RE: GRANADA VIEW DRAINAGE STUDY
LOT 208, UNIT 6, TOWN OF ATRISCO GRANT

The subject drainage study was approved and the plat signed on September 15, 1975. The attached reports are the amendments requested of the original report. I understand Tyree Surveying delivered the original report.

Re: Storm Drainage Study
Lot 208, Unit 6
Town of Atrisco

TYREE SURVEYING COMPANY			
201 EUBANK N.E. ALBUQUERQUE, NEW MEXICO			
GRANADA VIEW			
GRADING PLAN			
DATE: 8/75	SCALE: 1" = 50'	DRAWN: A.D.W.	SHEET 1
		CHECKED: R.E.T.	OF 1

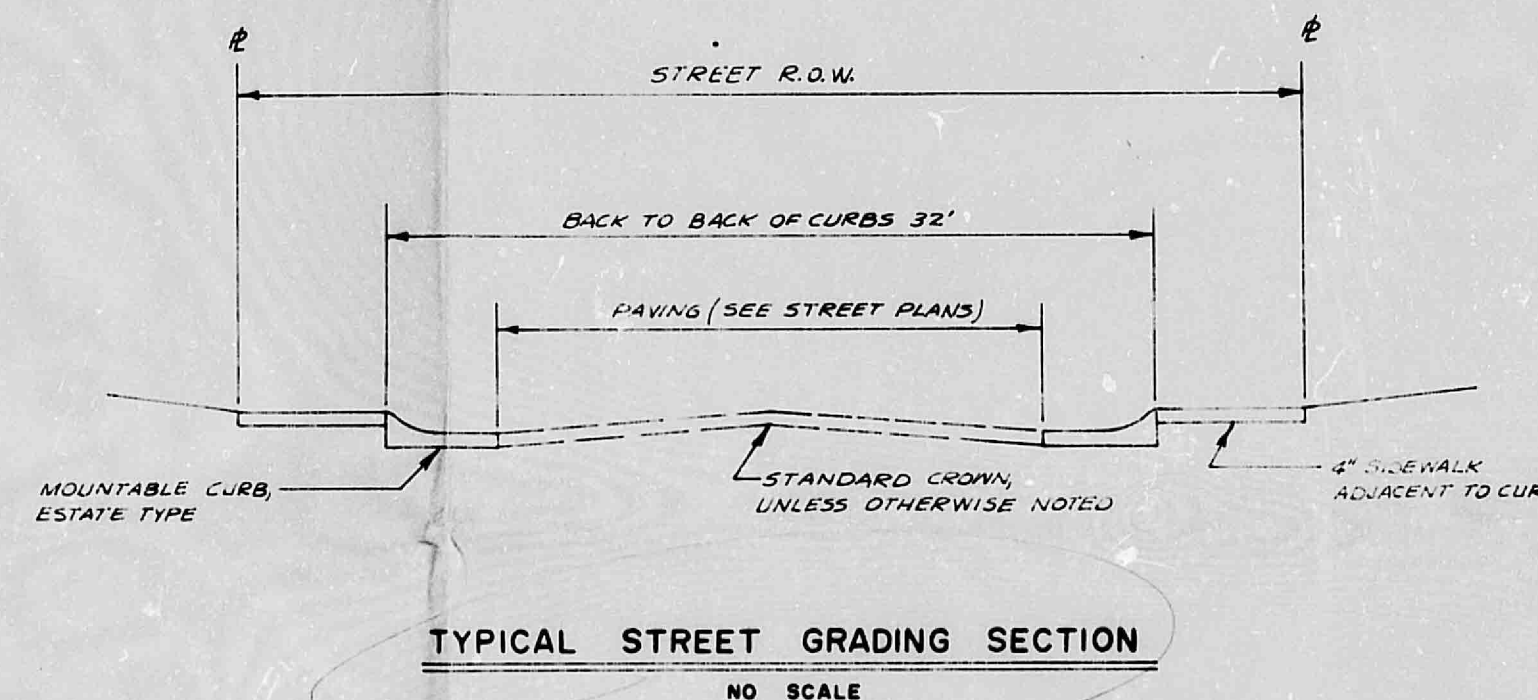
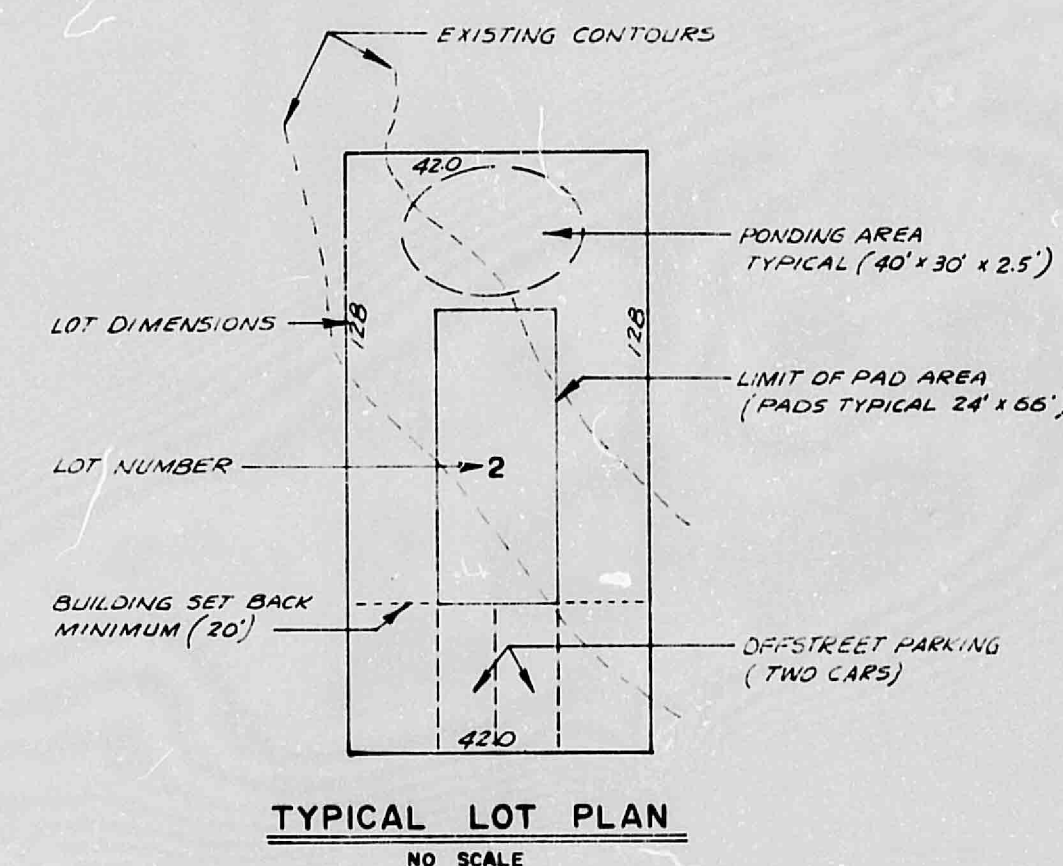
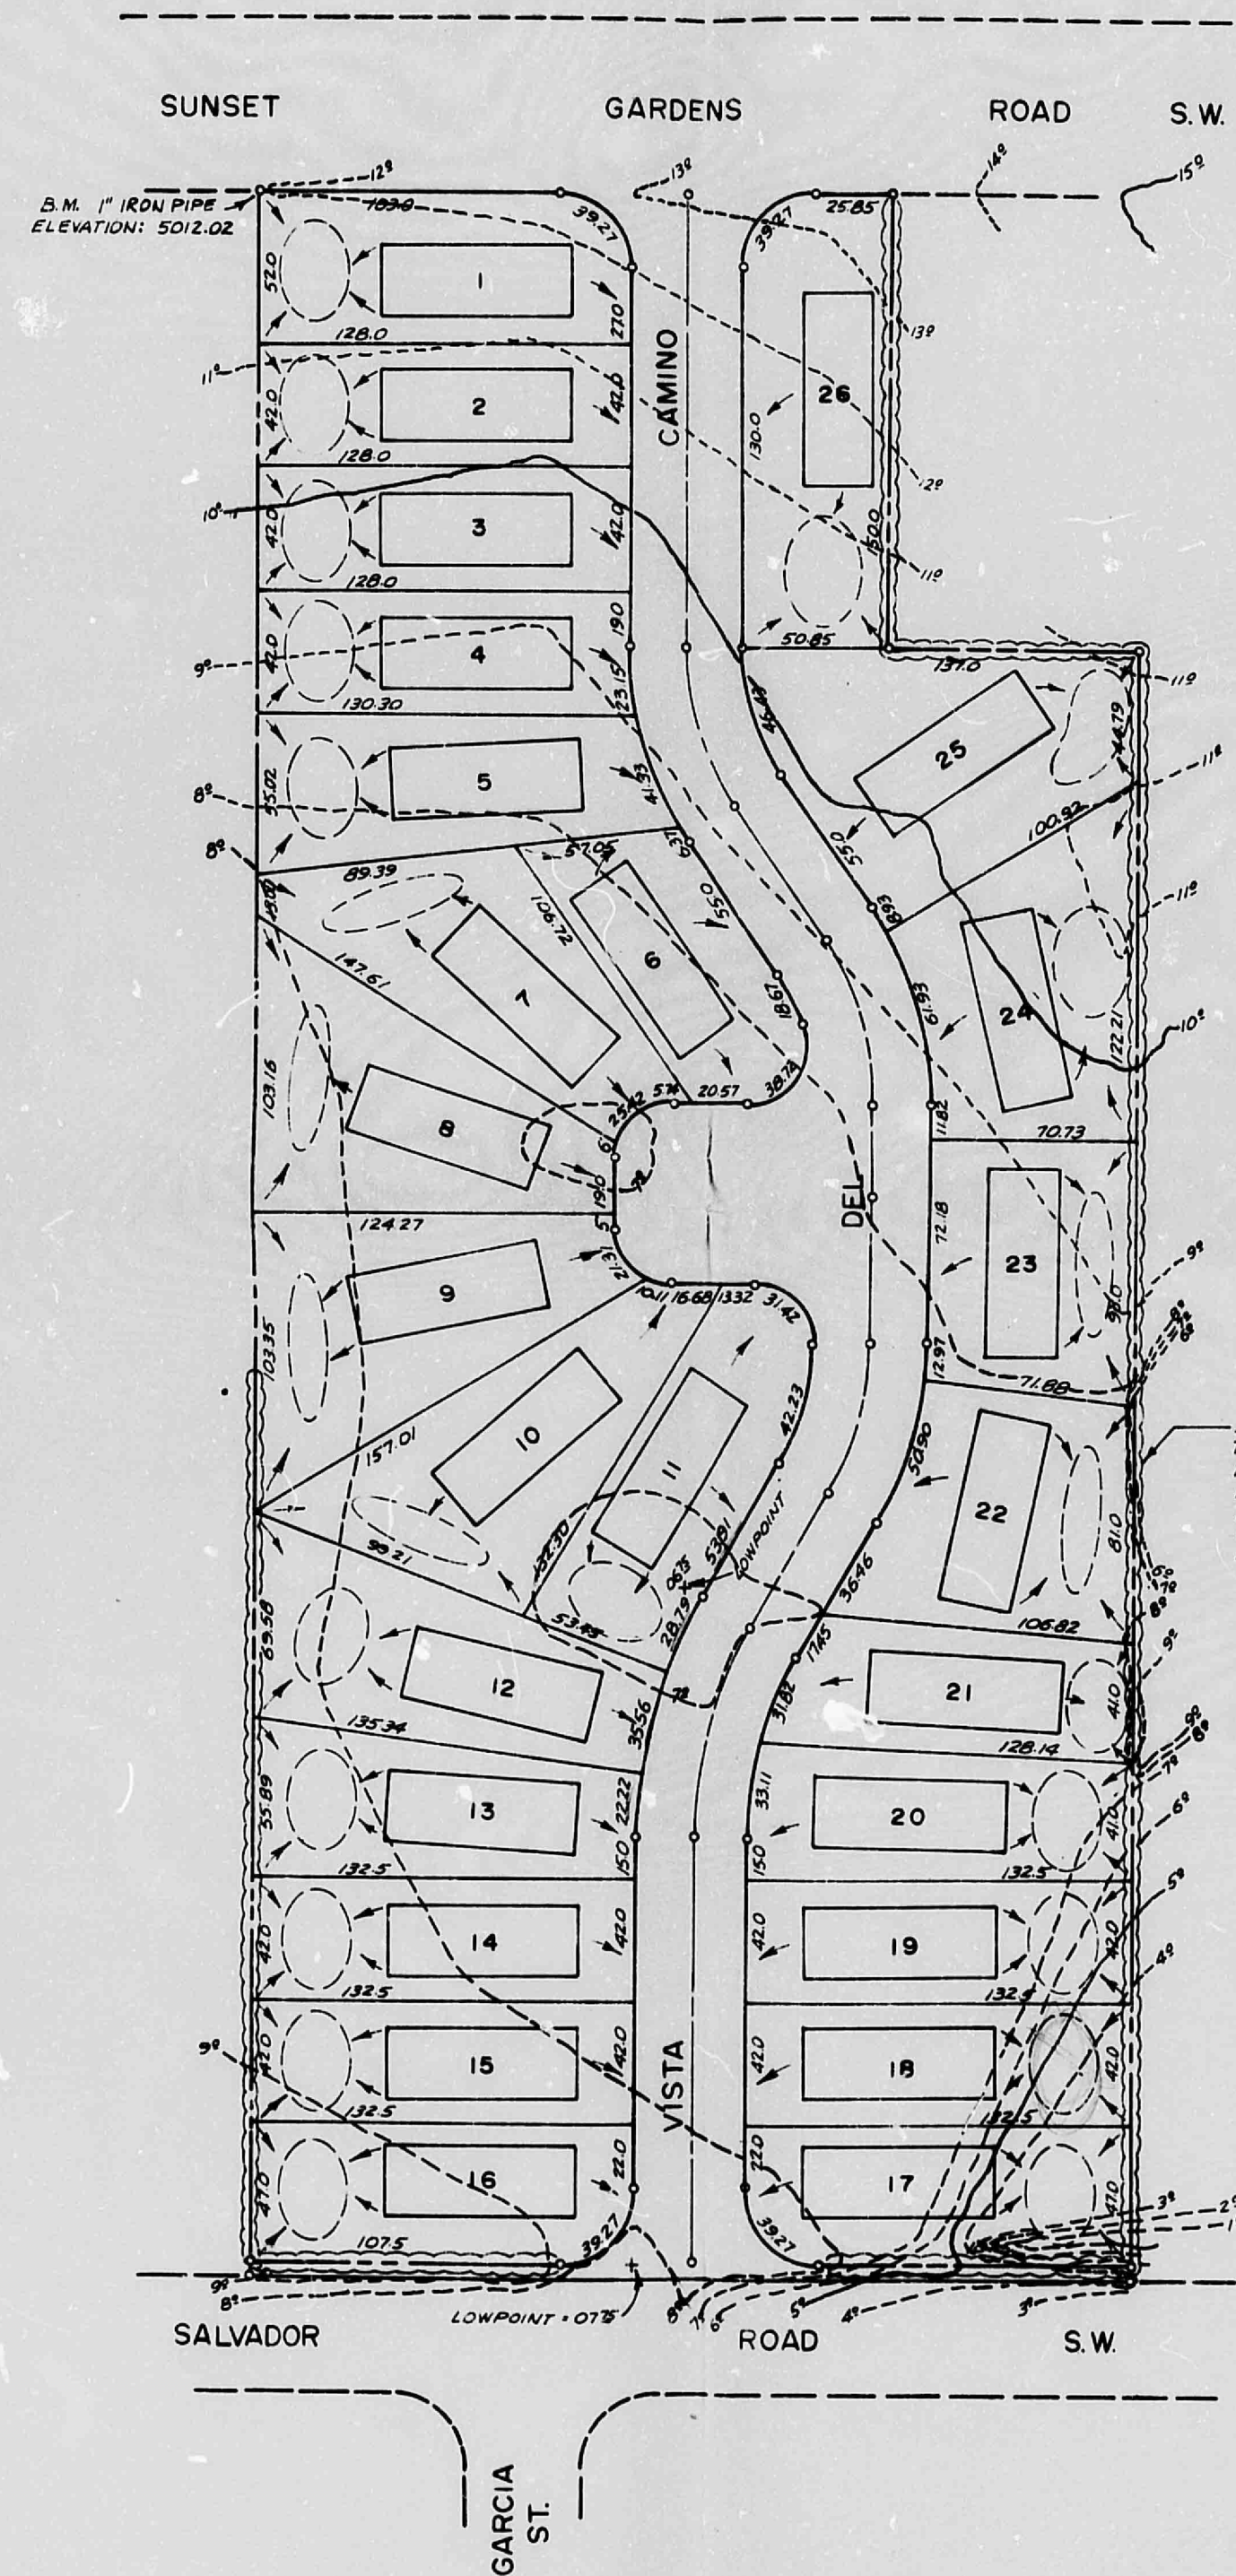
Attached is the revised Drainage Plan drawing incorporating your typical street section. Drainage capacity of the revised section is approximately 37 cfs at a slope of 0.0025.

Also included are revisions to the final grading plan which will insure flow from trailer roofs and driveways to the planned ponding areas. Typical ponds are to be forty (40) by thirty (30) feet with a maximum depth of 2.5 inches.
